Mr R Aston,
The Planning Officer
Welwyn Hatfield District Council,
Council Office
The Campus
Welwyn Garden City
AL8 0PB

29th November 2013

Council Office Extensions

Title Proposed Sections

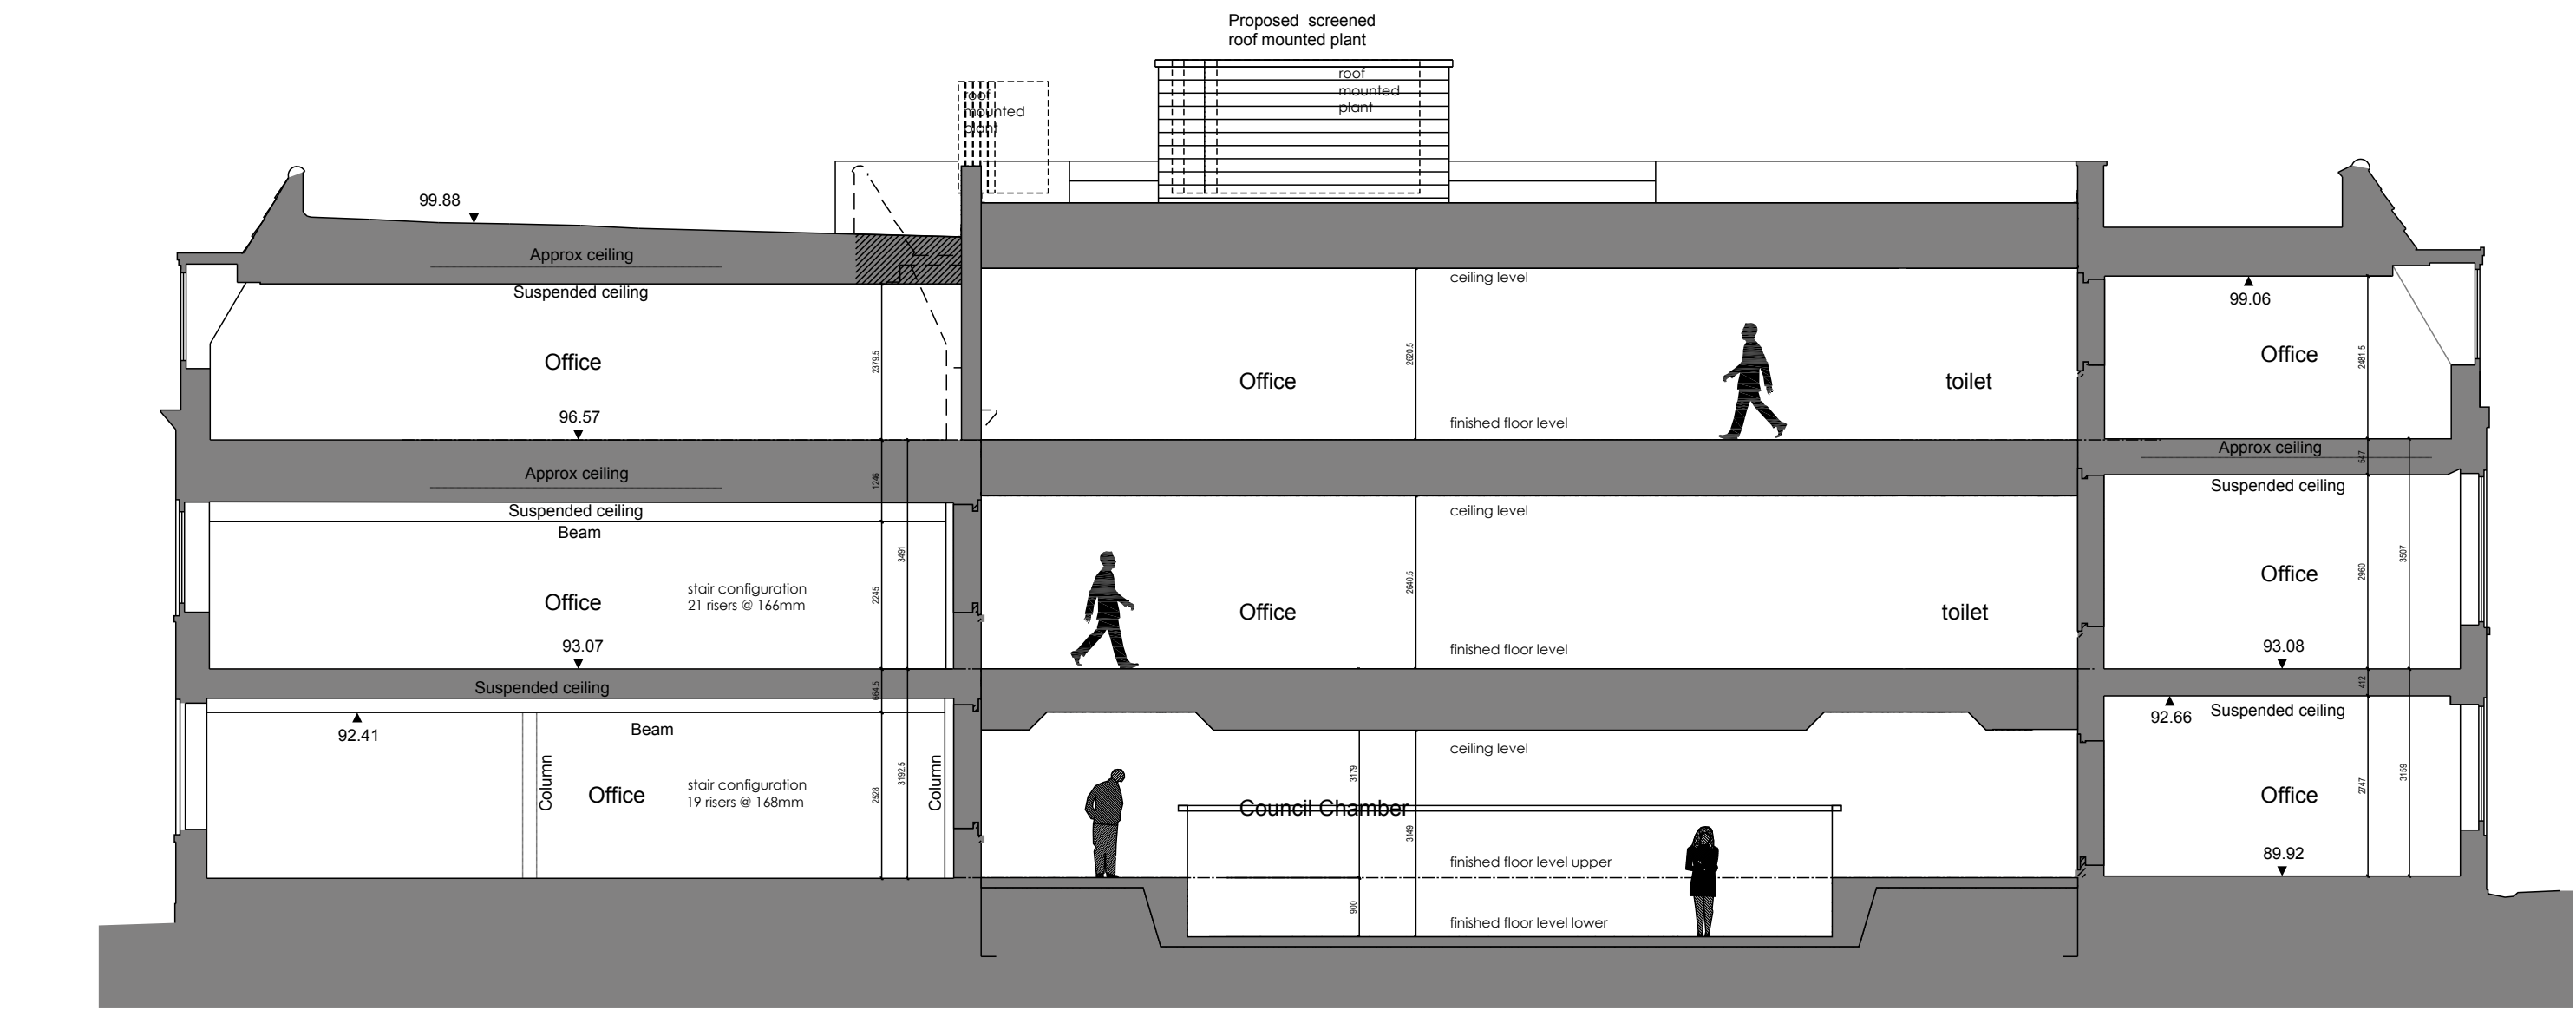
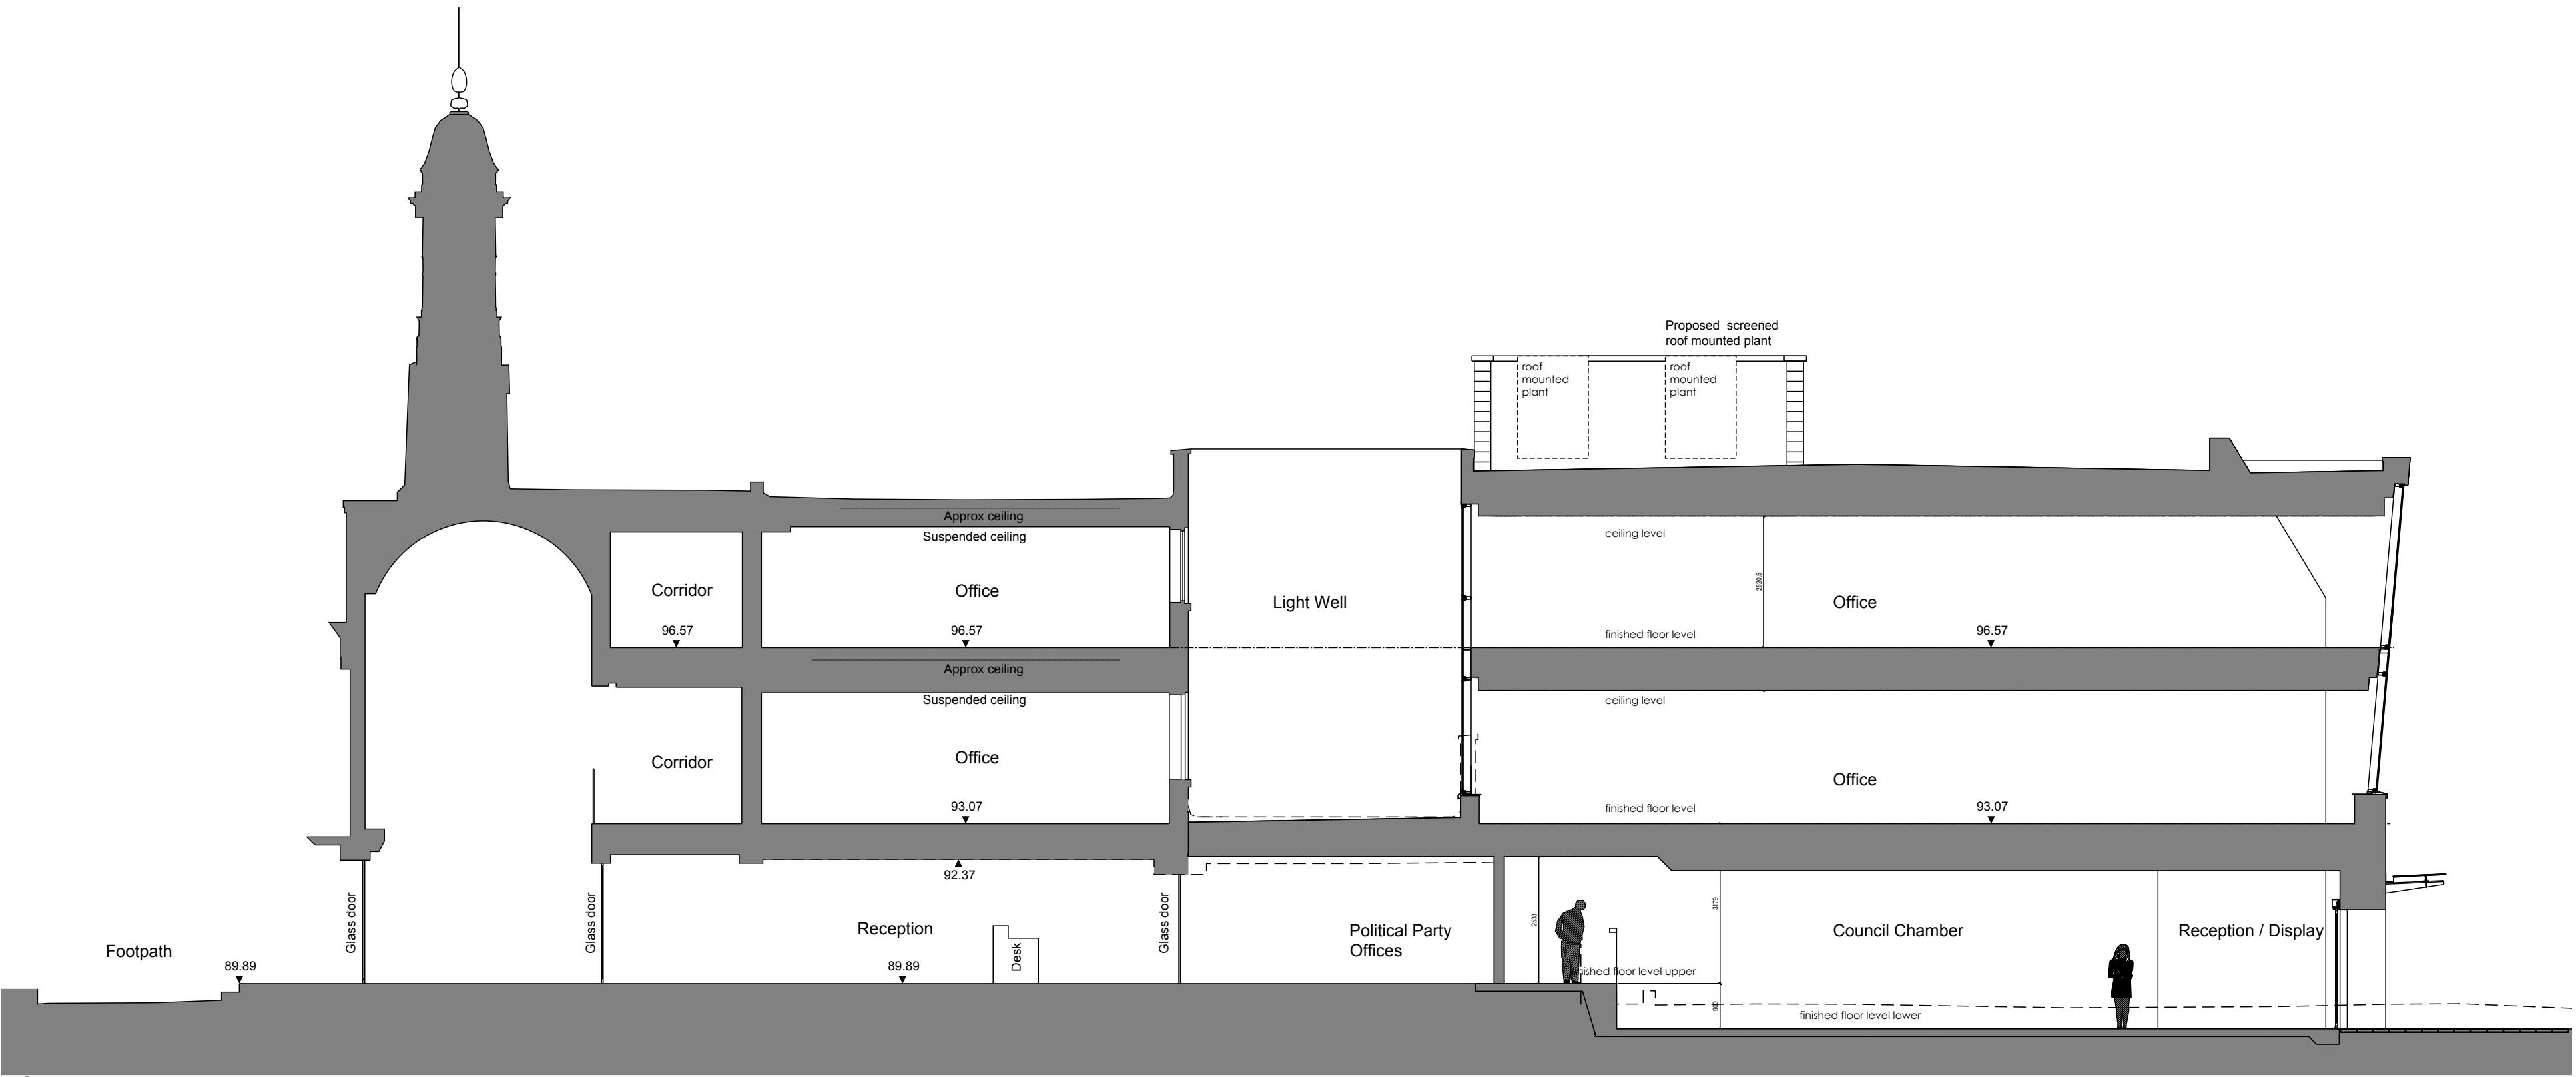
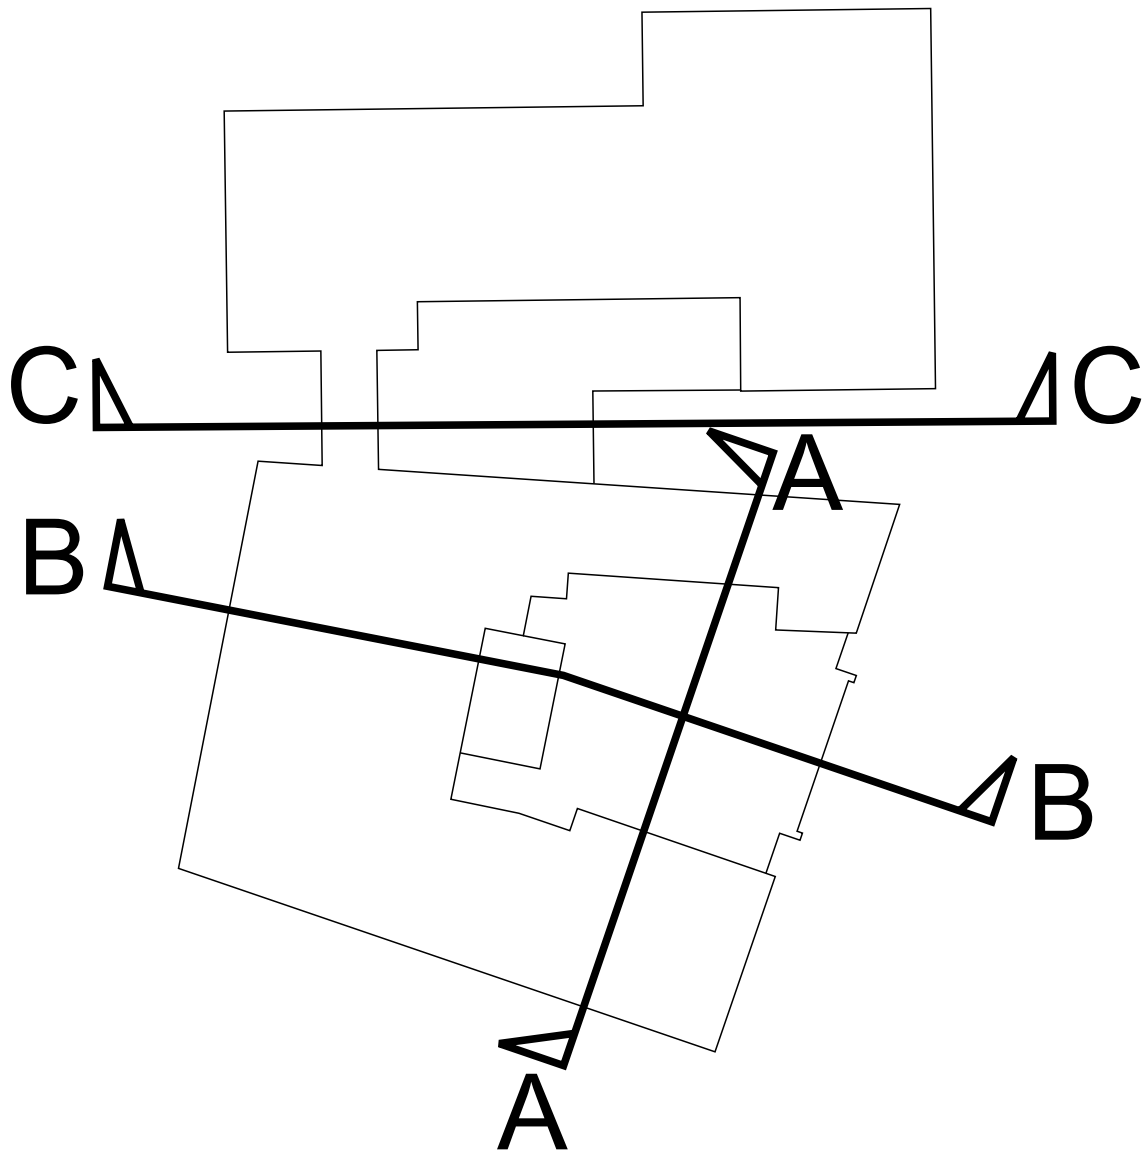
In the absence of so doing, I can only reiterate my previous comments to the effect that I find the architectural expression to this infill, coarse and lacking any sensitivity that one would expect to see for such a significant infill to a major and important early Garden City Building.

For example it exhibits a pronounced vertical emphasis in a group of buildings that essentially have a horizontal expression. It's glazing is poorly proportioned, out of scale, and is contained within a meaningless band that ignores the existing parapet lines and pushes aggressively forward of the pitched roofs to the upper storey.

A great opportunity is being missed to create a sensitive and exquisitely detailed modern glazed infill spanning between or even forward of the ends of the existing wings and which exhibits a horizontal expression adopting minimalist glazing bar technology and which it also shows a conscious awareness of the existing parapets and roof profiles to provide a worthy addition to the architecture of Welwyn Garden City.
